**KIRKLEES METROPOLITAN COUNCIL  
INVESTMENT & REGENERATION SERVICE**

**DELEGATED DECISION TO DETERMINE PLANNING APPLICATIONS**

Reference No:	<b>2025/62/90582/E</b>
Site Address:	Khan Food Store, 636, Huddersfield Road, Ravensthorpe, Dewsbury, WF13 3HL
Description:	Change of use from shop to cafe/takeaway with external canopy and installation of replacement of shop front with new shutter
Recommending Officer:	Nina Sayers

**DECISION - REFUSED**

PROPOSED GROUND FLOOR PLAN

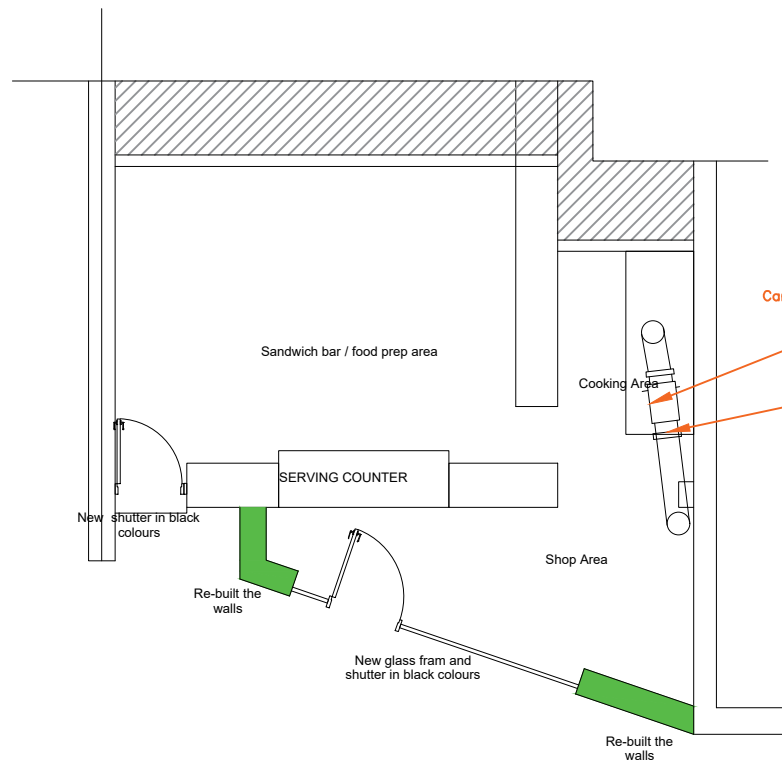
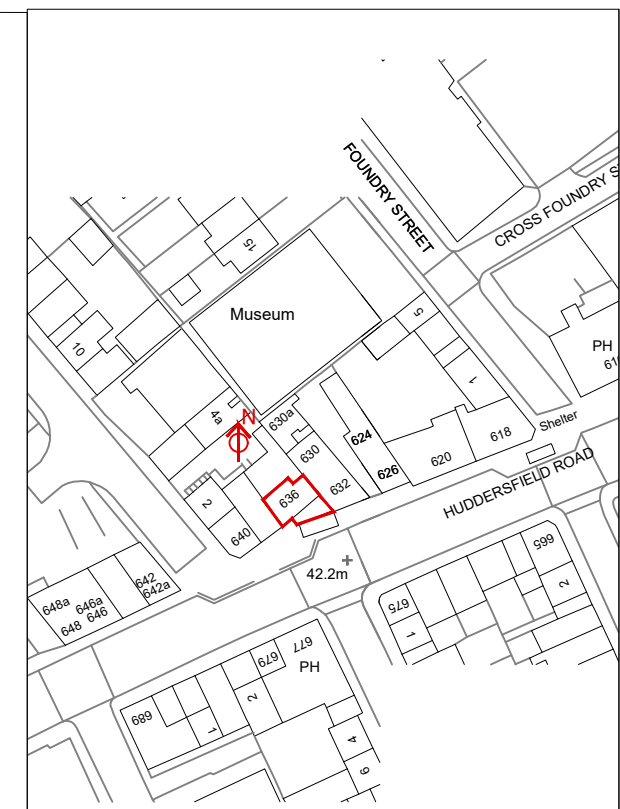
The scheme proposes a sandwich bar/food prep area to the rear of the shop and a shop area to the front, with a serving area adjoining to two. A cooking area is proposed in the back corner. The applicant has confirmed that the proposal would serve a hot food takeaway.

A 300dia. extractor is proposed to the front, above the shop frontage.

PROPOSED FRONT ELEVATION
(south east)

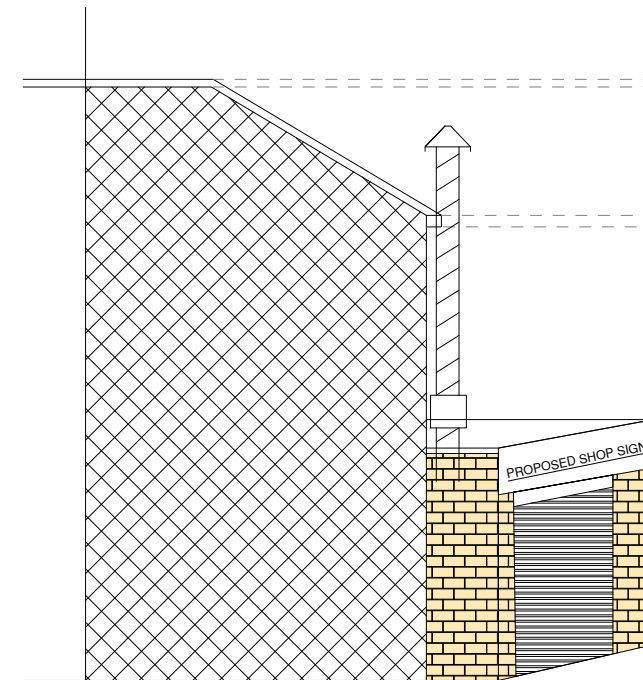
The proposed external changes to the shop front would replace an existing timber framed shop front with a stone structure. The submitted plans show the proposed materials would match the existing stone building and therefore the proposed changes are considered an improvement to the existing.

There is a proposed flue to the front of the property. A flue located on the principal elevation is unacceptable as it would appear incongruous and would result in harm to visual amenity. Whilst officers may be able to support a flue to the rear elevation, subject to impact on residential amenity, it is noted that in this instance the application boundary cuts through the middle of the building and therefore this is not possible in this instance. As the principle of development is considered unacceptable and as there does not appear to be an appropriate alternative location, no amended plans have been sought in this instance.

3. A flue located on the principal elevation of the property would be an incongruous addition to the building and would fail to integrate sympathetically into the wider street scene. The proposed development would therefore result in significant harm to the visual amenity of the host building and wider street scene contrary to HFT6 of the Hot Food Takeaway SPD, LP24 of the Kirklees Local Plan and Chapter 12 of the NPPF.
